# City of Albuquerque Stormwater Construction Site Inspection Report

ESC File No.	H14E111	Project Name:	Phoenix Apartments		
NPDES Id. No.	NMR10047E	Location:	2818 4th St. NW		
8/25/2022	Owner	Contractor - NMR1047P			
Operator	Michael Dreskin	J&S Development			
Contact name & title	Michael Dreskin	Jose Rodriguez			
e-mail	<a href="mailto:mdreskin@aol.com">mdreskin@aol.com</a>	<a href="mailto:rodriguez3003@hotmail.com">rodriguez3003@hotmail.com</a>			
Contact Phone #	249-7788	440-5104			
COA Inspector	Doug Hughes	Start/End Time:	10:30-11:30am		
Construction Phase:	Staging				
Type of Inspection:	<input checked="" type="checkbox"/> Regular	<input type="checkbox"/> Storm Event	<input type="checkbox"/> Past Storm Event >0.25"	<input type="checkbox"/> 311/Complaint	<input type="checkbox"/> Follow Up
Weather at time of inspection?		Clear		Temperature: ~ 75	
Estimated date of last storm 0.25" or greater		6/26/2022

DRAINAGE MANAGEMENT PLAN

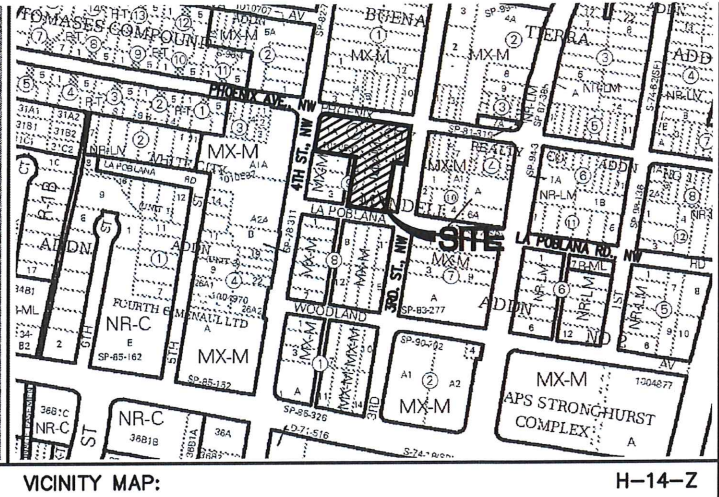
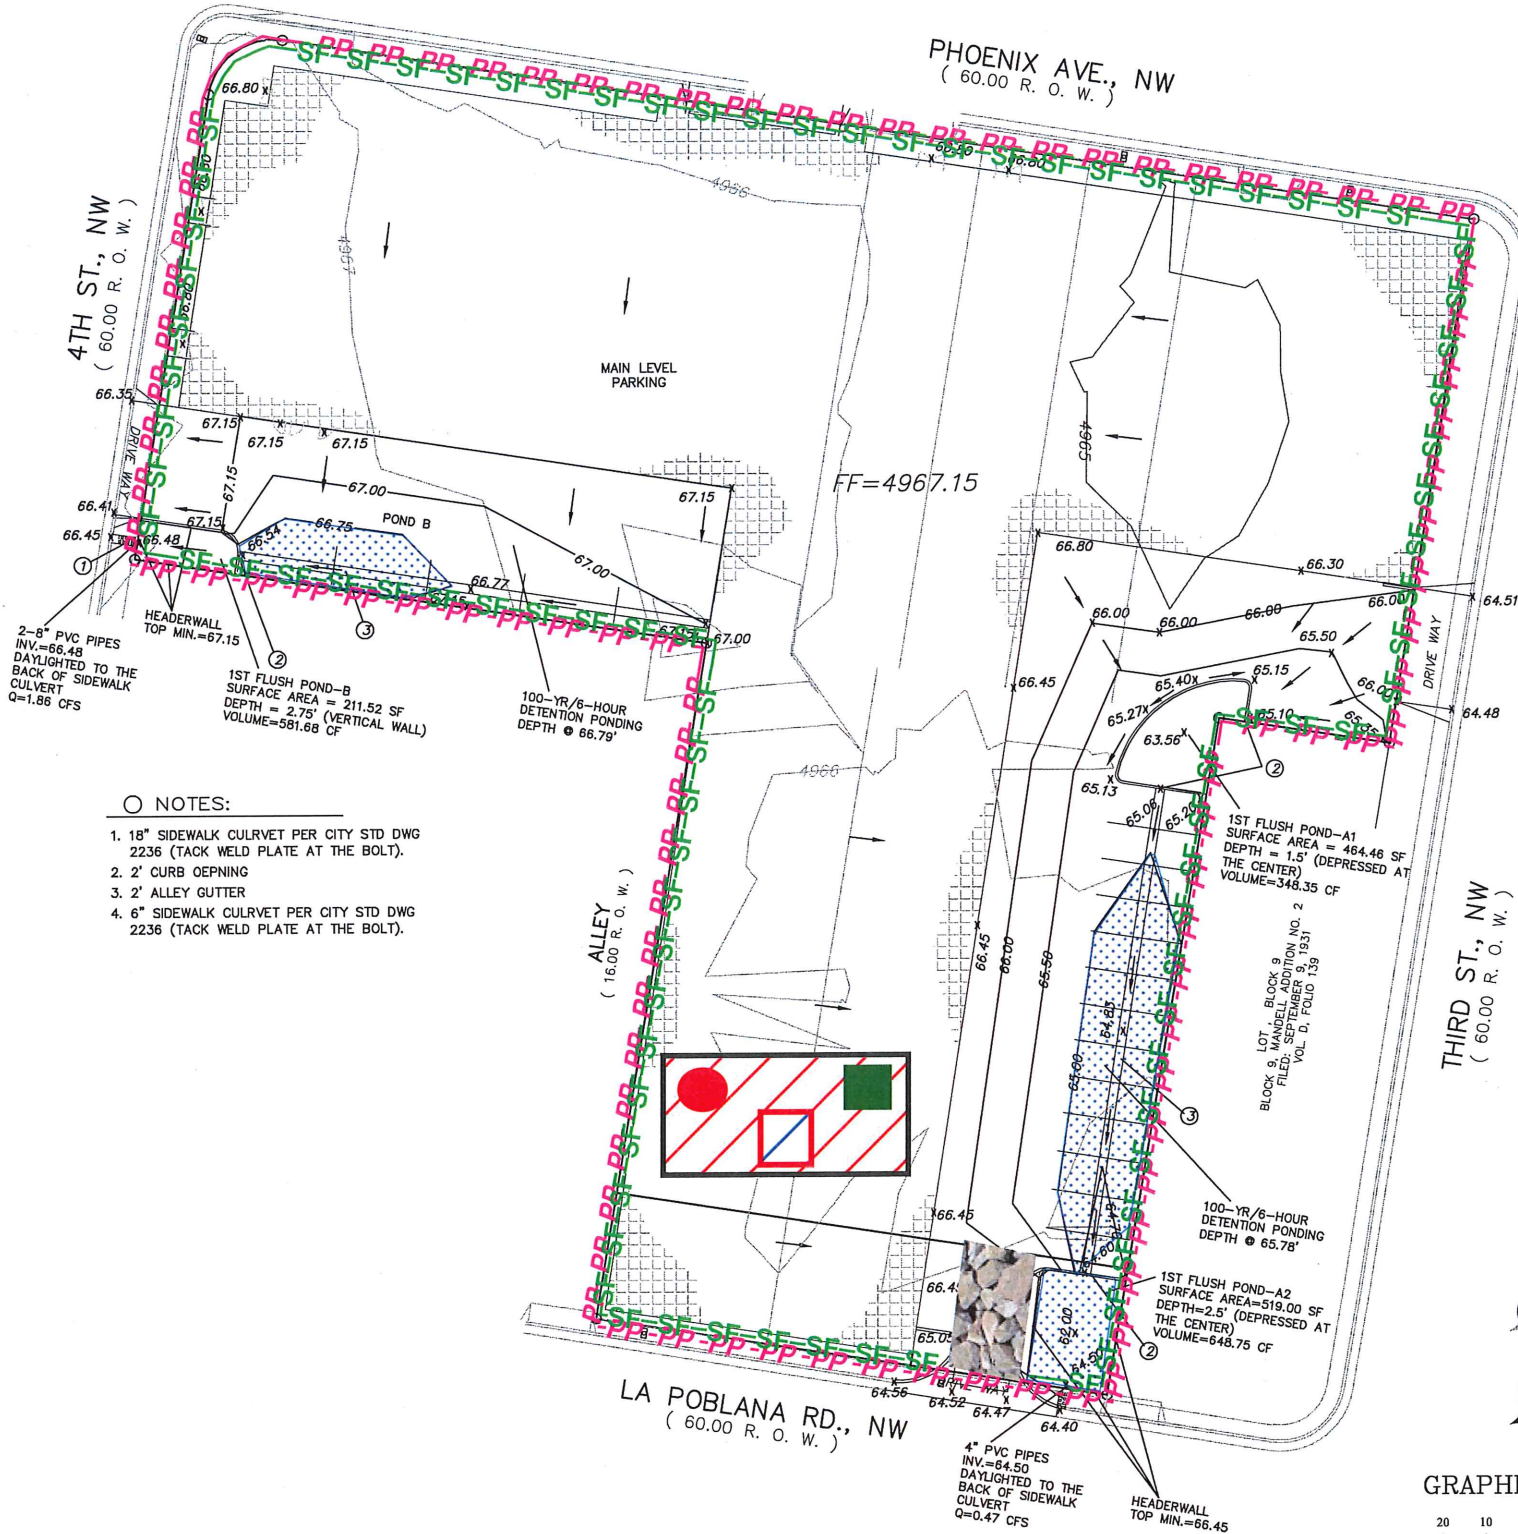
Item Number	Deficiency/ Corrective Action				
1	The SWPPP wasn't up-to-date at the time of inspection. Self Inspection Reports and Corrective Action Logs were missing.				
2	The 2017 CGP and NOIs were still not updated to 2022 permits. 2022 CGP and NOIs missing.				
3	Concrete washout container was covered by trusses and non-functional. Reset the washout and direct wash water from concrete, paint, and stucco into a leak-proof container per CGP 2.3.4.				
	Discharge off site? (Y/N)	no			
4	Self Inspection Reports	required	Latest report Date:	8/18/2022	
Notes:					
The SWPPP is in conex box in new building. Call Jose 440-5104.
